4.21.2021
Koke Consulting Group Inc
Permit #: 2012-199 4225 89th Ave SE

Please note the following changes have been made and bubbled on the plans to the above listed project per your requests:

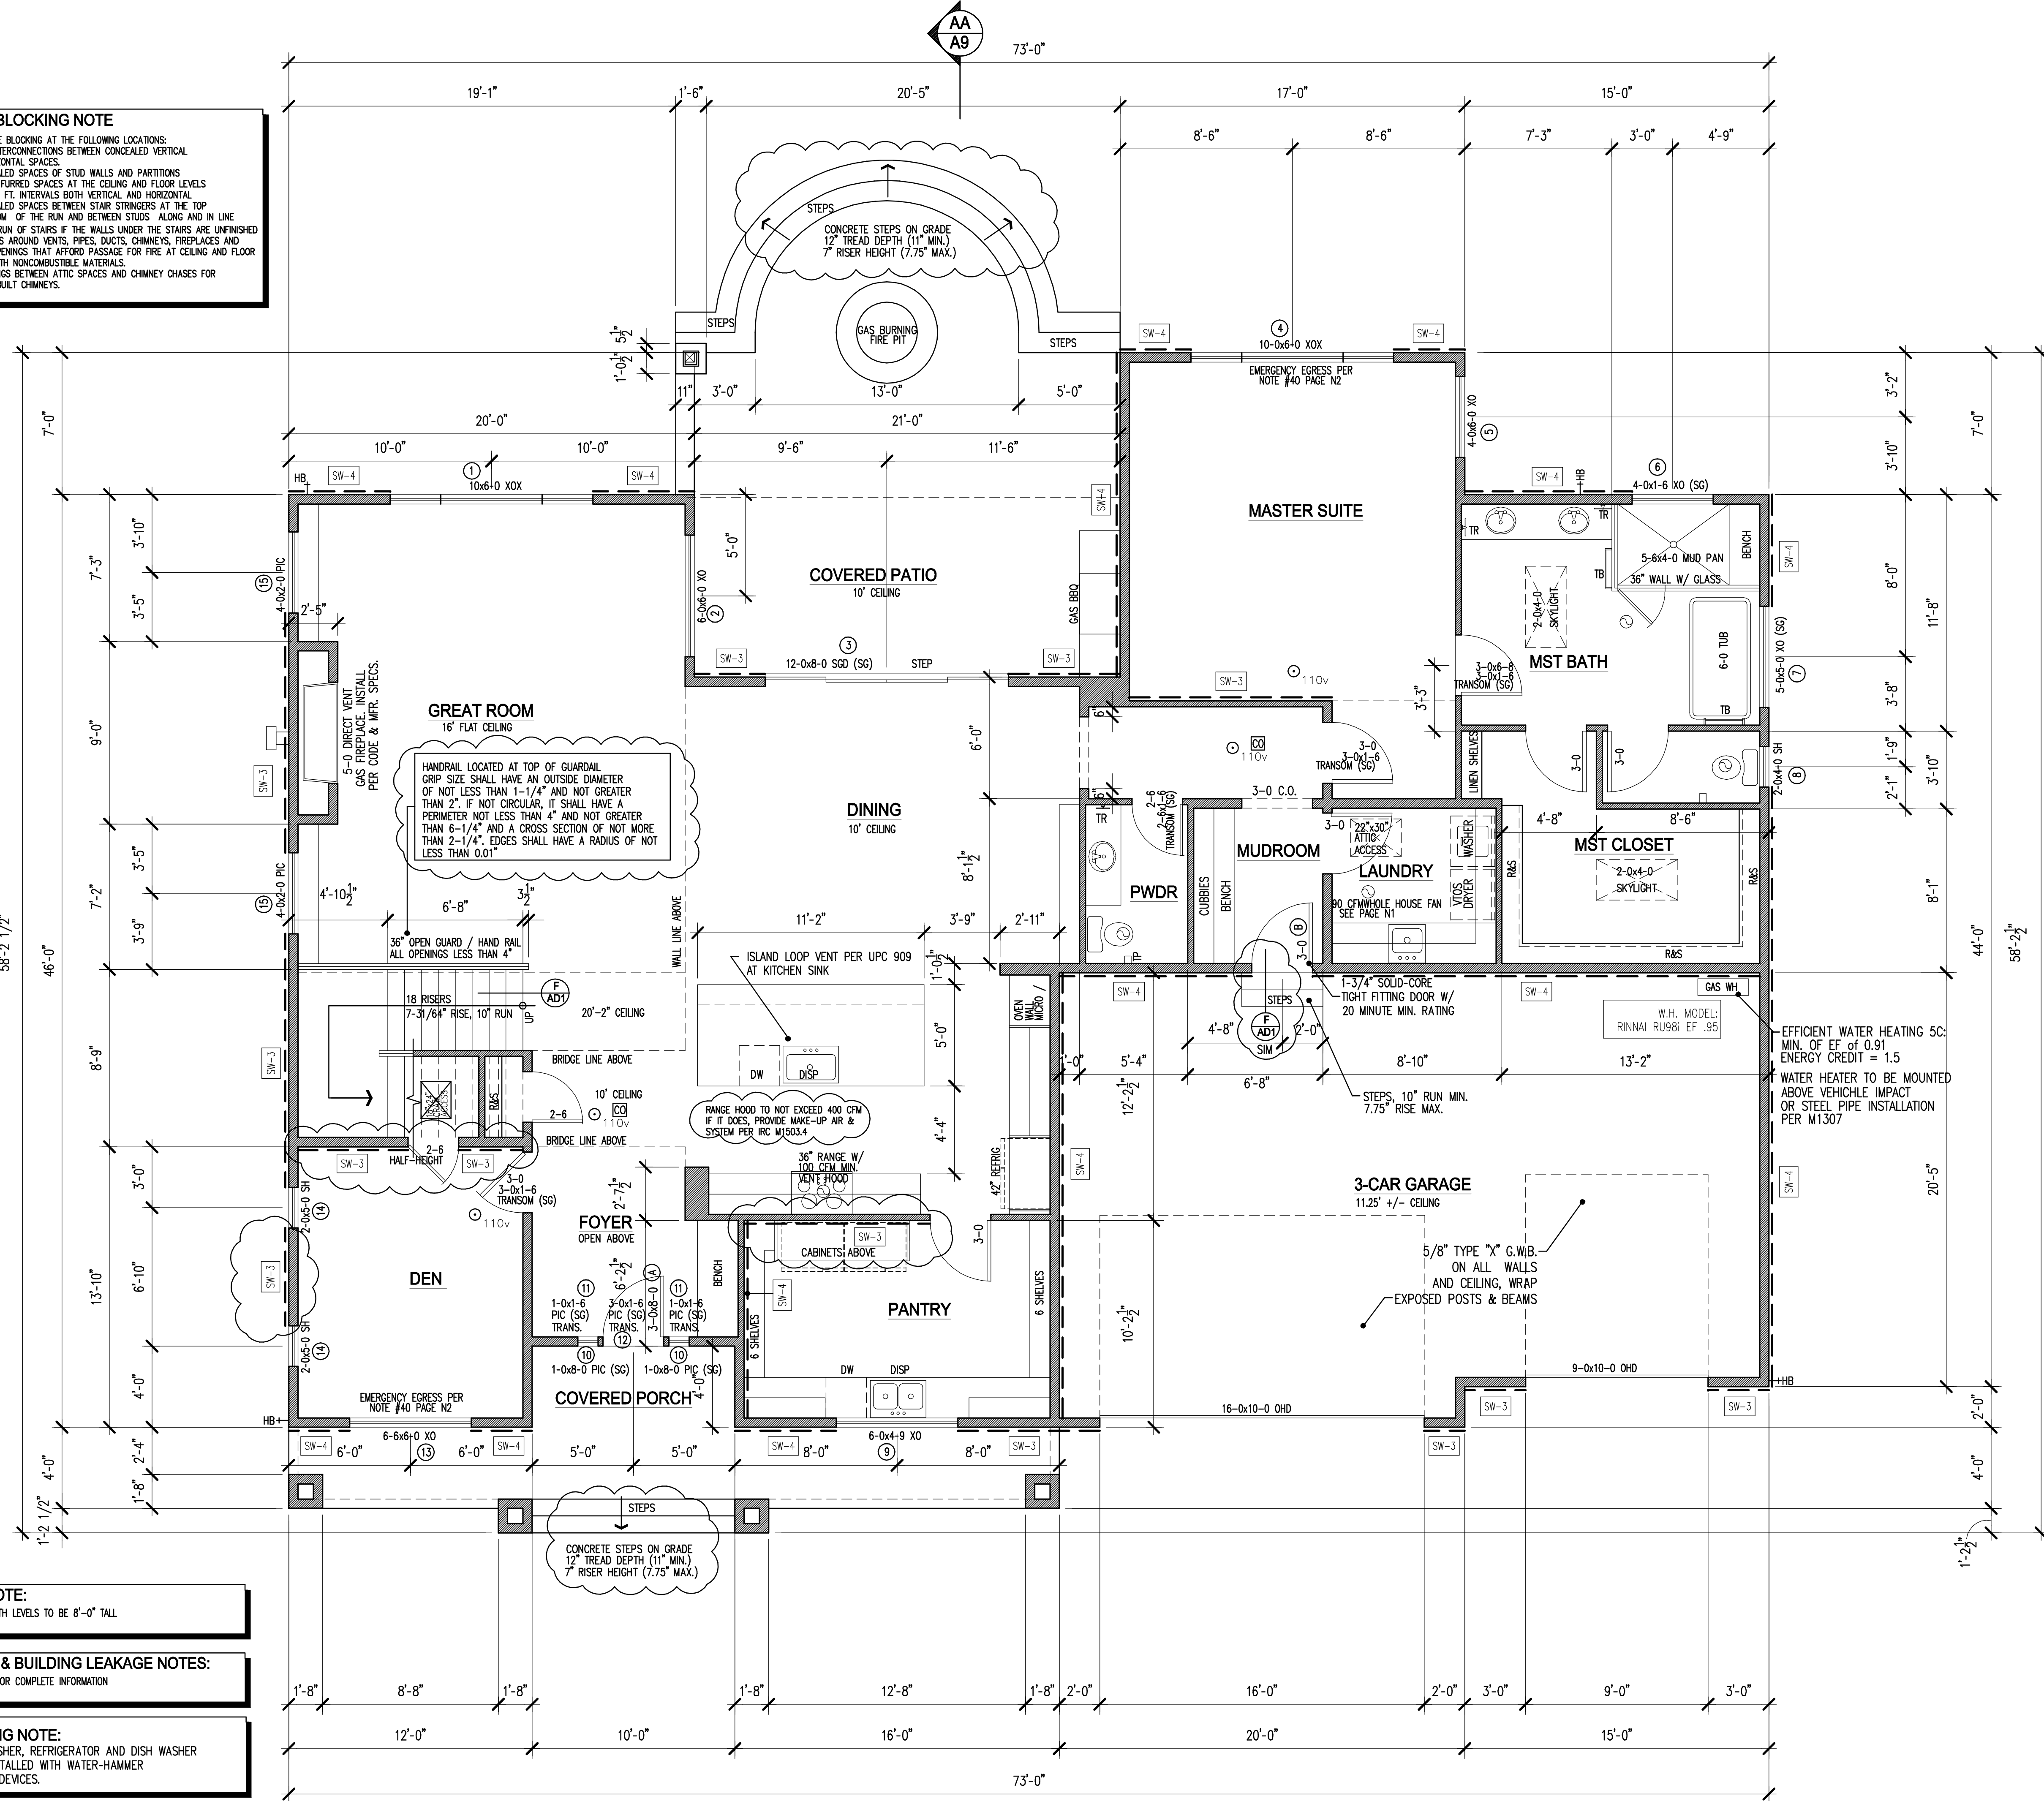
1. We do not intend for a hood in excess of 400 cfm, so a note has been added to sheet A2 that if it is installed to design for the requirements of IRC M1503.4

REVISED  
4.21.2021

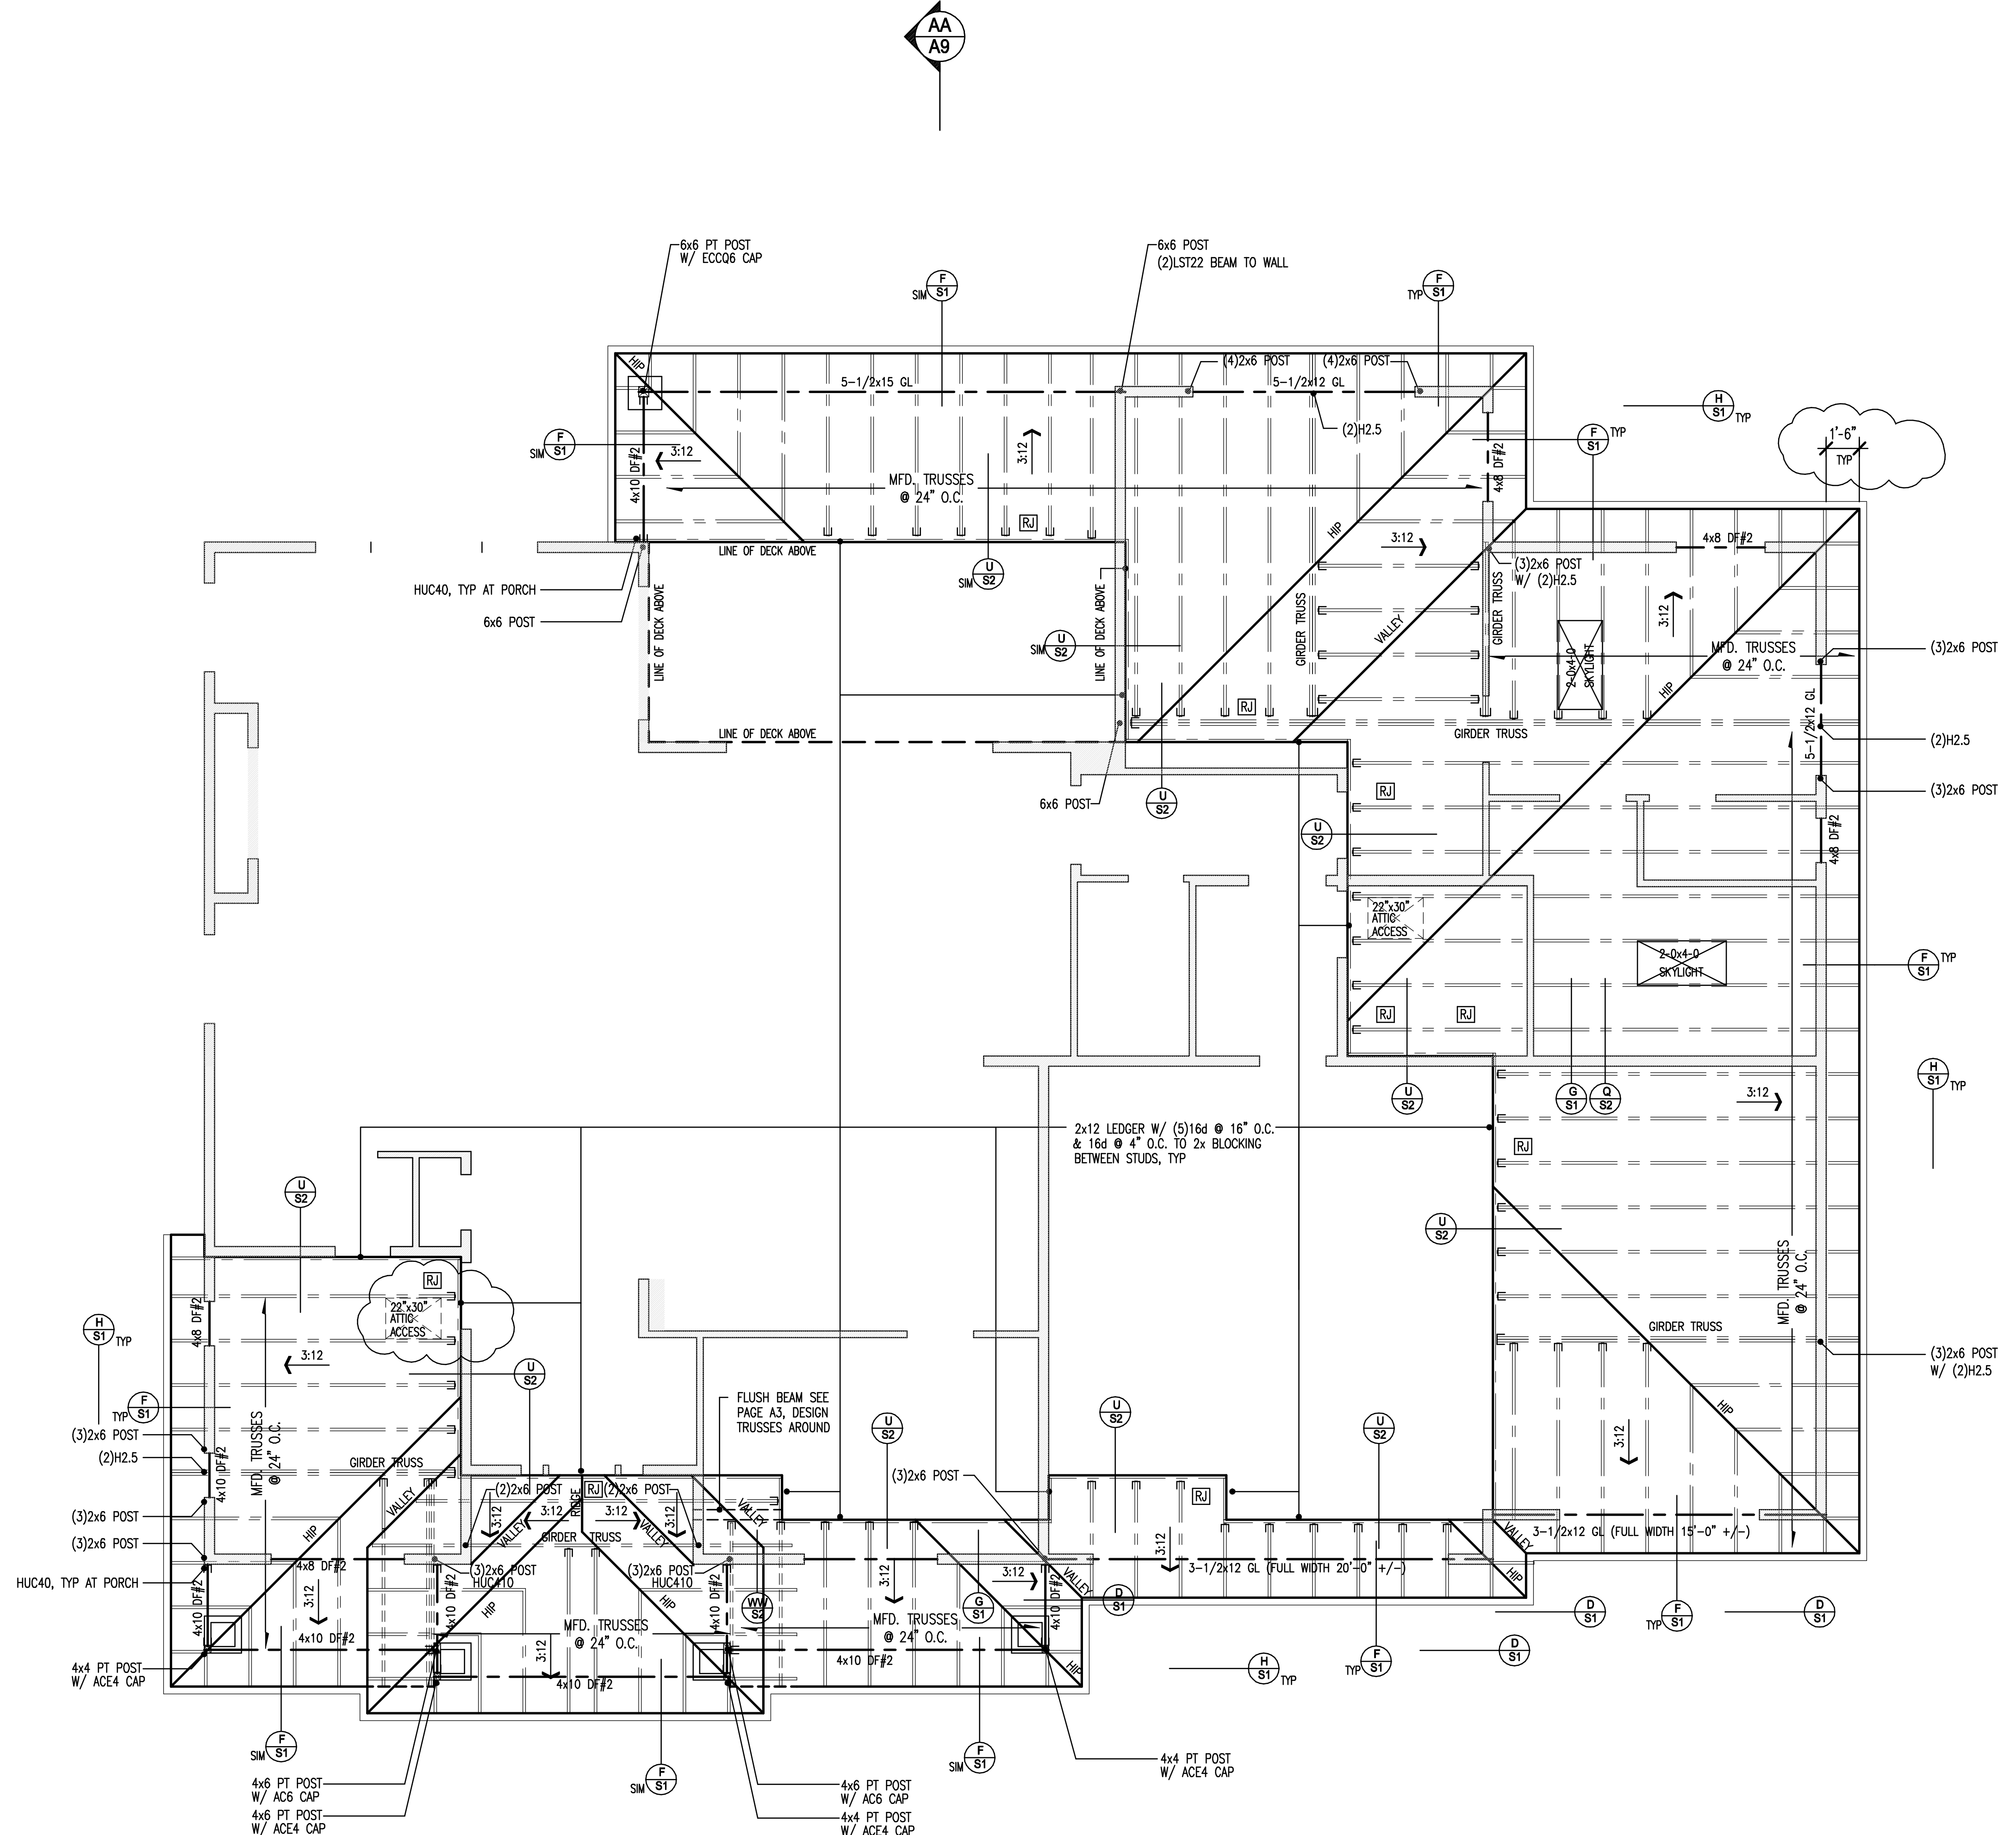
4. Tempered safety glass has been noted in four additional locations on page A4 at the stairwell.
 5. Laminated glass is called out at the skylight.
 6. Detail M / AD1 noted that the manufactured stone wasn't to be in contact with the ground and the distance was to be governed by the manufacturer – which is not determined at this point. So your note of a minimum distance of 4" has been added. For further help of compliance, the bottom row of stone on the elevations has been removed.

COMPUTER FILE NAME  
**A5**  
 SHEET NUMBER

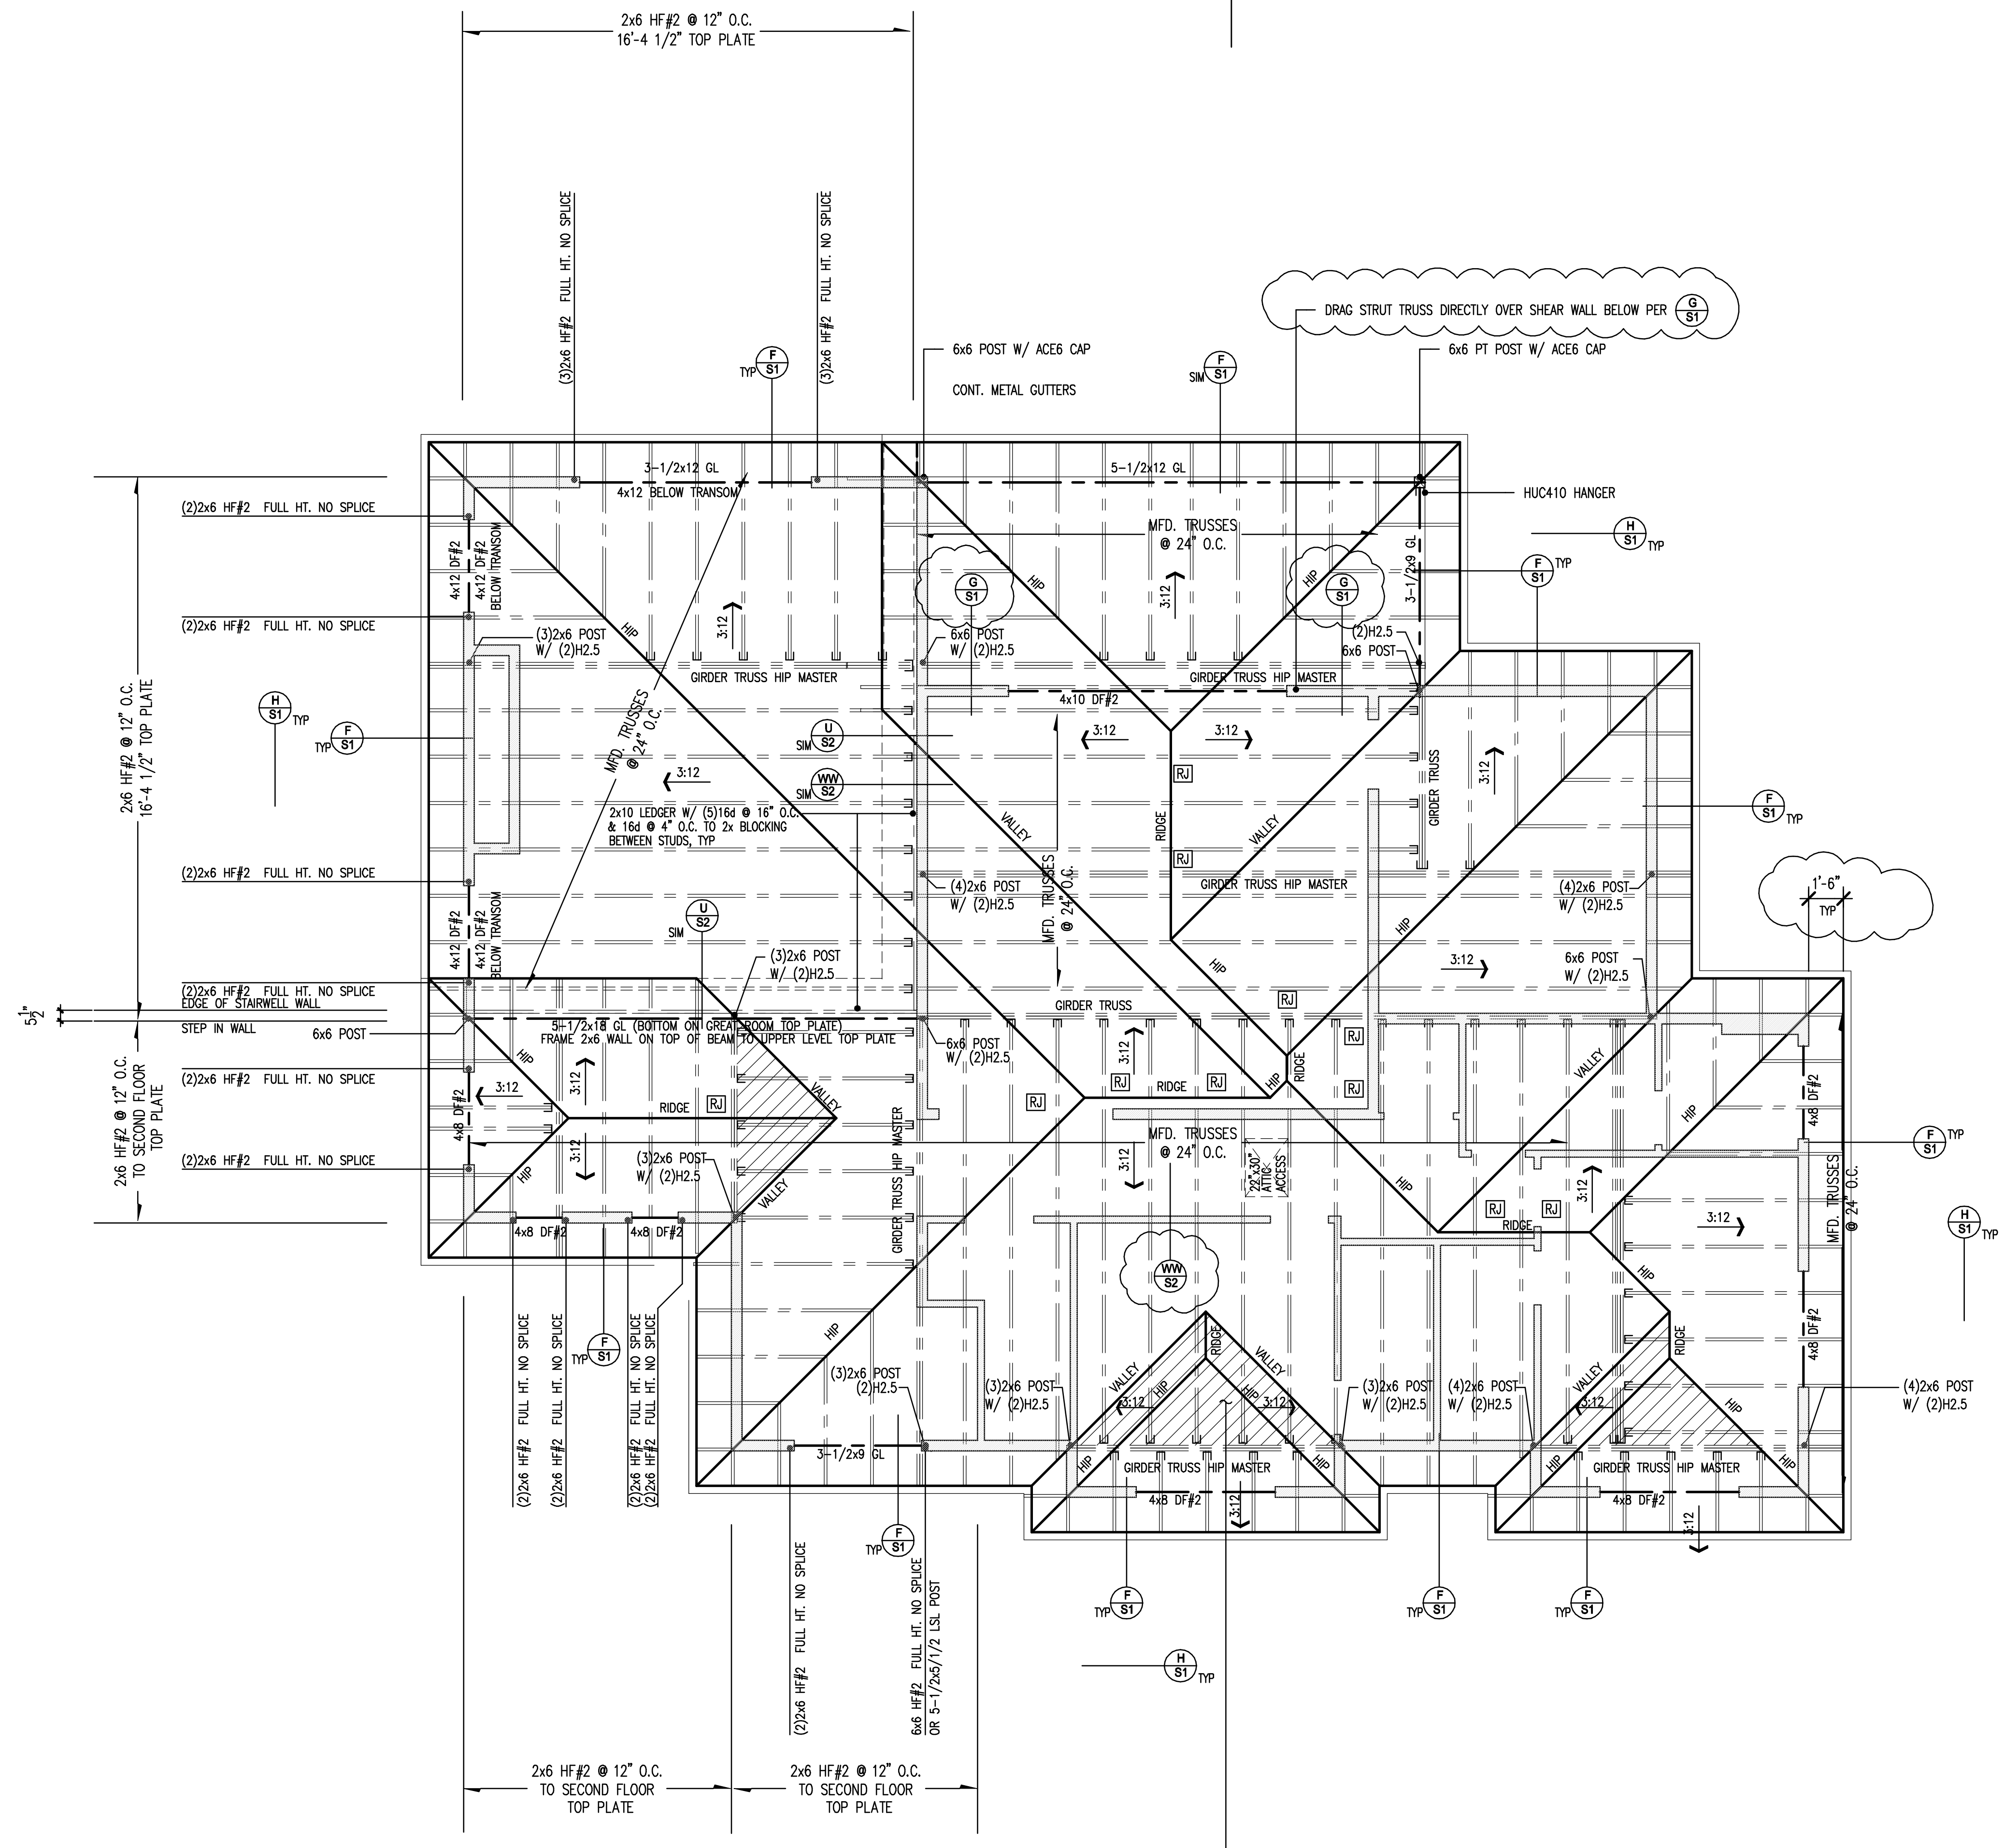
7. The building section on page A9 previously detailed the footing drains, but has been modified to show the roof drain tight-lines.
 8. Attic access is now shown on the low roof framing plan Sheet A5 at the den.
-
